City of Albuquerque Stormwater Construction Site Inspection Report

Project Name:	Santa Monica Estates				
Location:	Brentwood Blvd. & Santa Monica				
Site Contact Name & Agency	Chris Kelsey - 350-0493	ESC File No.	D18E054F_Stillbrooke		
	ckelsey@stillbrooke.com	NPDES Id. No.	NMU001955		
Inspection Date:	02/27/19	Start/End Time:	1020/1145hrs		
CoA Stormwater Inspector:	Timothy Sims, Stormwater Inspector				
Present Phase of Construction:	house consturction				
Type of Inspection:	<input type="checkbox"/> Regular	<input type="checkbox"/> Storm Event	<input type="checkbox"/> Post Storm Event >0.25"	<input type="checkbox"/> 311/Complaint	<input type="checkbox"/> Follow Up

Erosion Sediment Control Plan

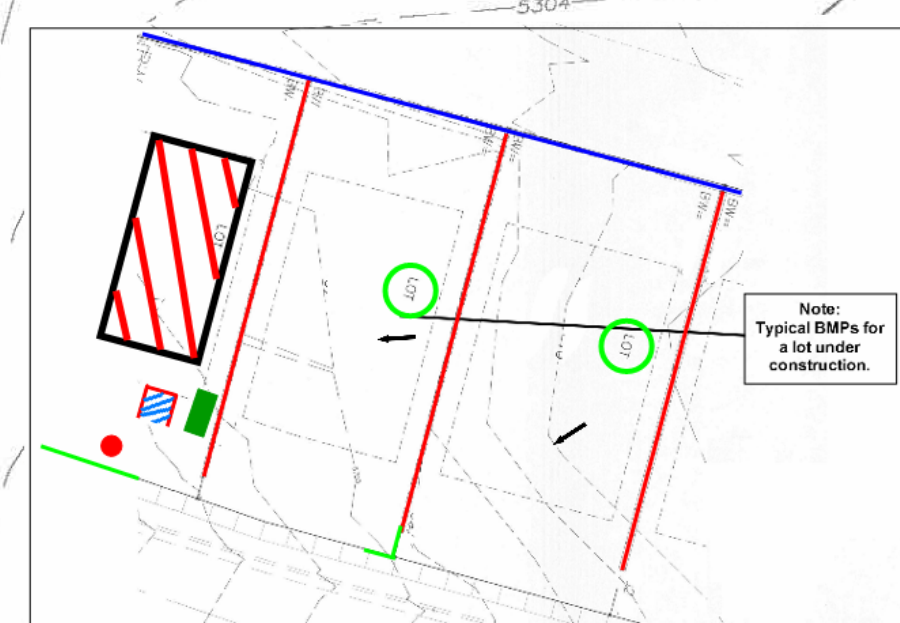
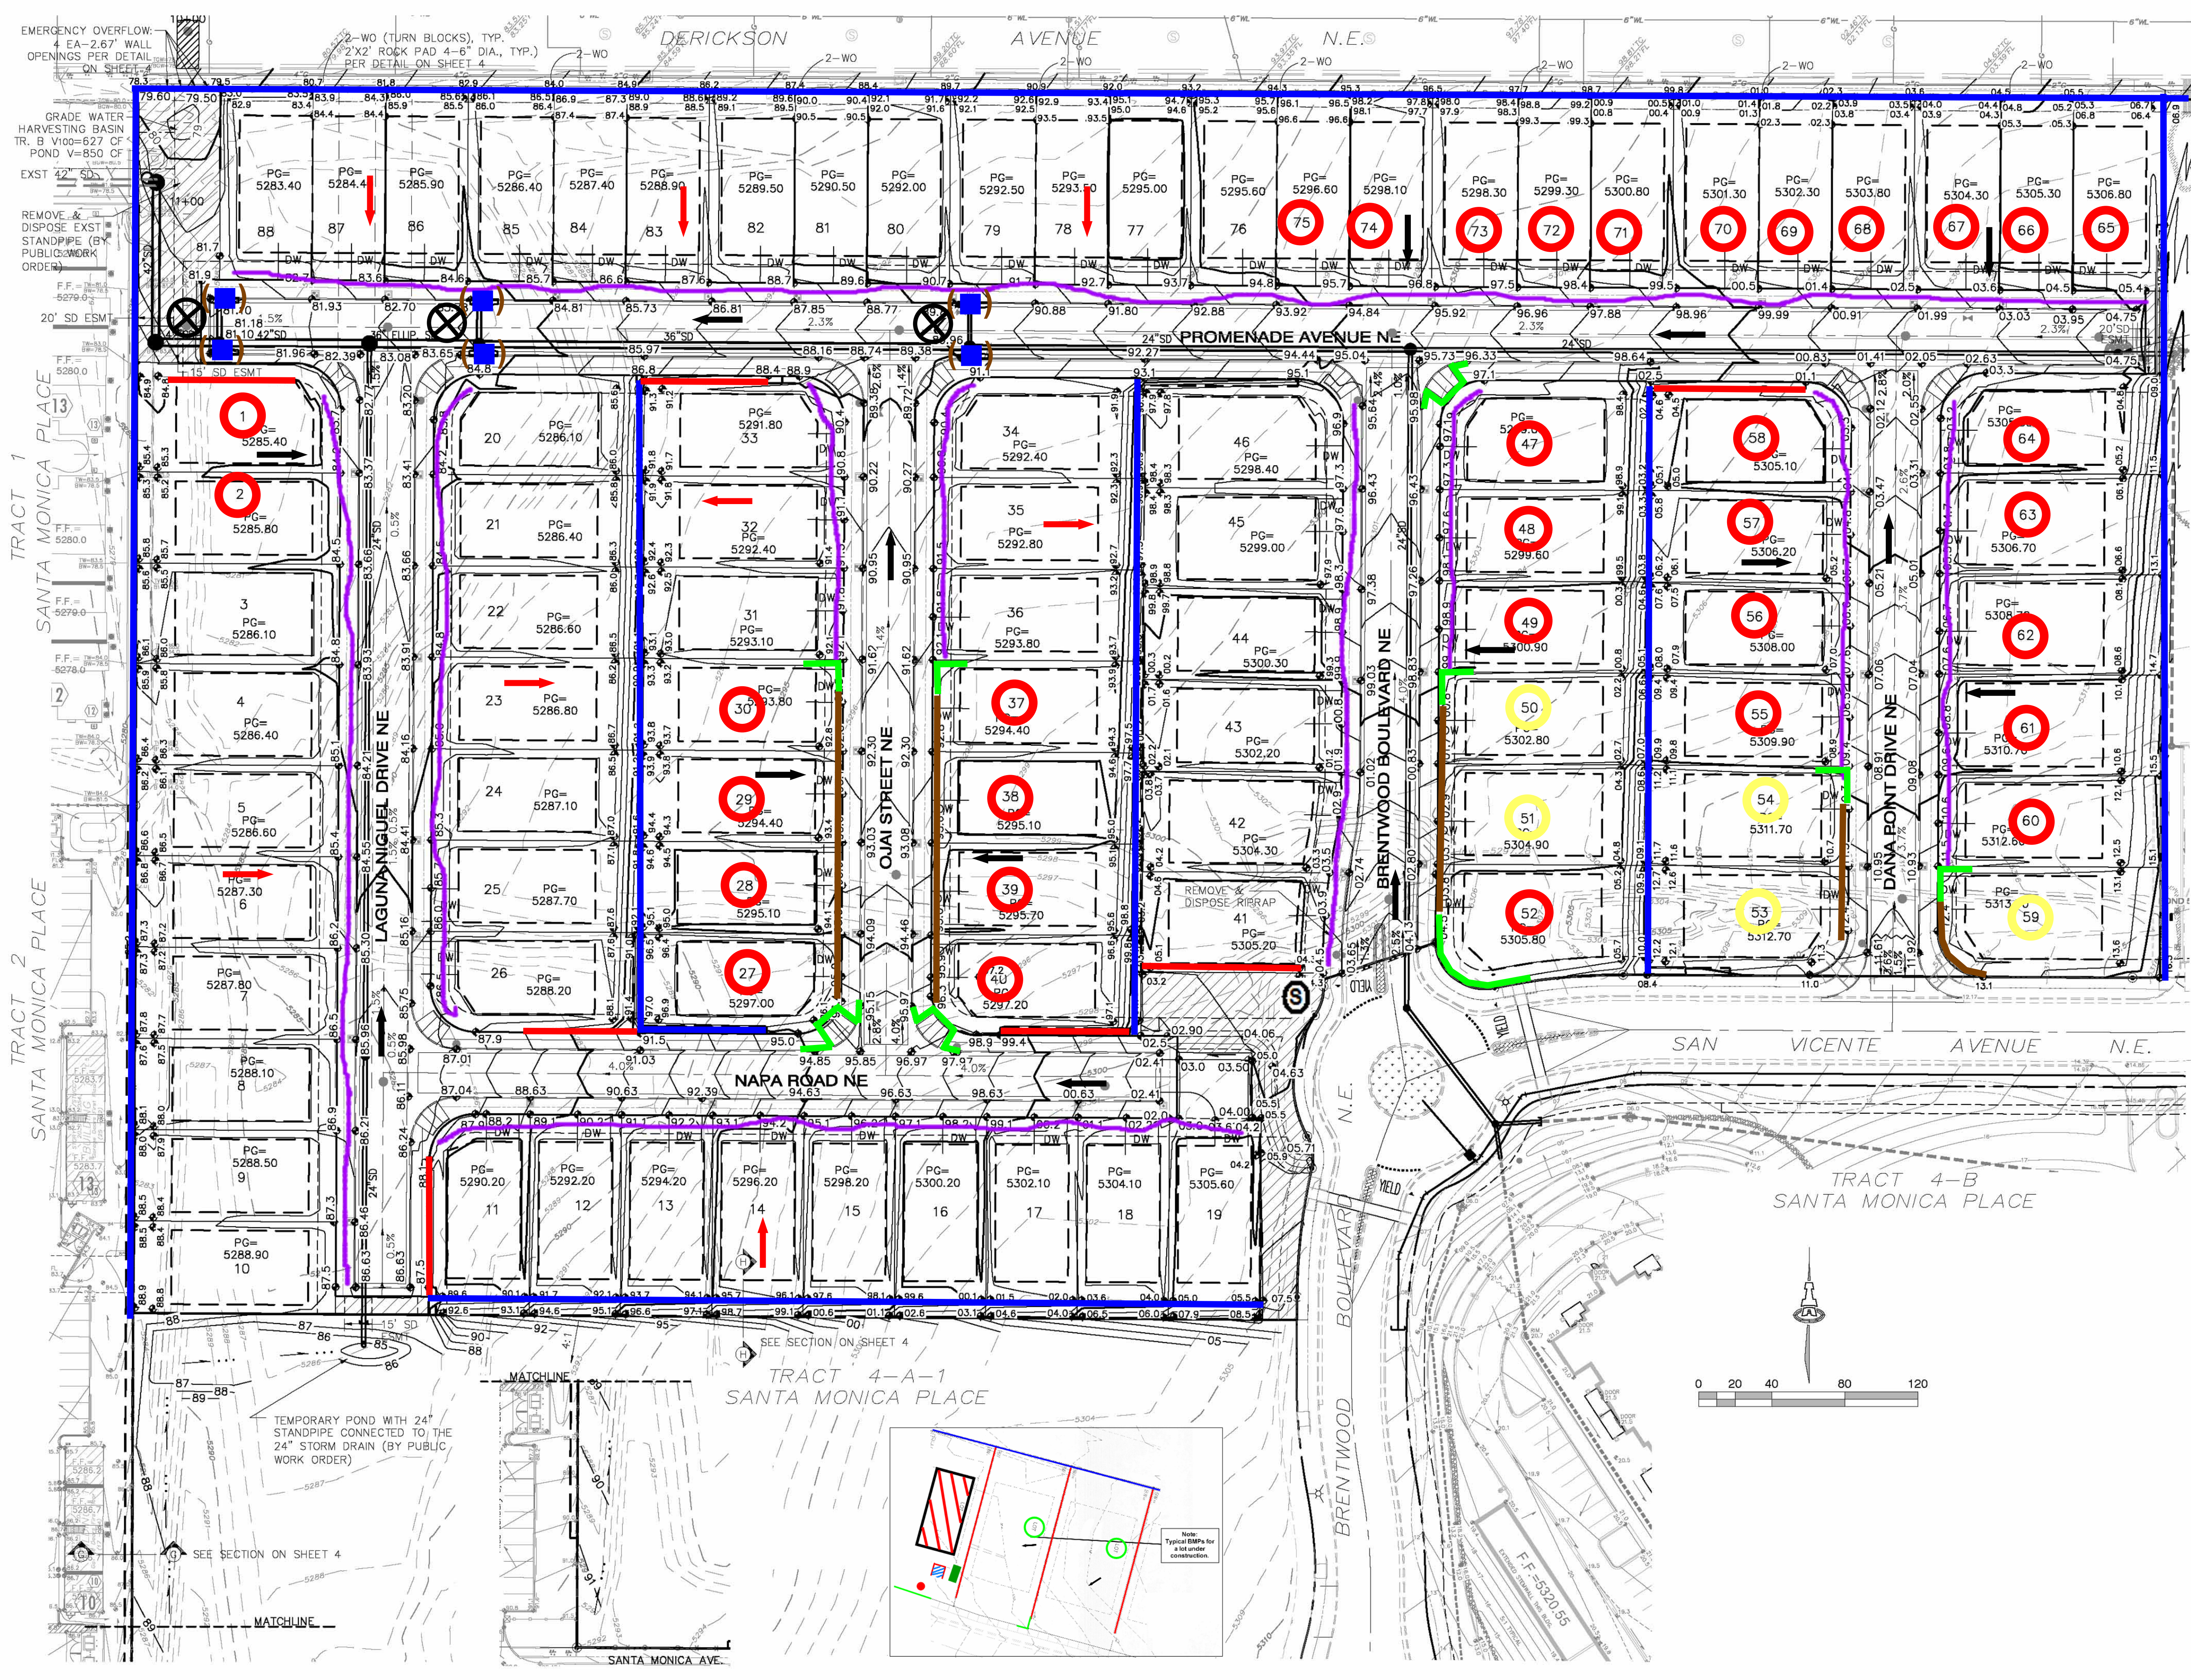
2.2.3	Sediment control along any perimeter	x	sediment BMP is required behind curb for all lots not turned over
2.2.3	Sediment control along any perimeter	x	Ojai Street requires silt fence mitigation and cleannig

2.2.5	Manage stock piles		
2.2.6	minimize dust		
2.2.10	Protect storm drain inlets		
2.2.10	Protect storm drain inlets	x	BMP's on Promenade Ave require refreshing

2.3.3	Building material storage		
2.3.3	Fuel, oil, hydraulic fluid, petroleum products and chemical storage		
2.3.3	Construction and domestic wastes	x	Several lots have litter and construction debris - clean

2.3.3	Construction and domestic wastes	x	Refuse locations need to be water tight and the ability to be covered
2.3.4	Washing applicators used for paint, stucco, concrete, etc.	x	cementous wash out on multiple lots - clean

2.3.4	Washing applicators used for paint, stucco, concrete, etc.	x	Provide and utilize concrete washout facility
2.3.4	Washing applicators used for paint, stucco, concrete, etc.

Notes:	Ojai Street, Dana Point Drice and NAPA require cleaning due to track out. - clean
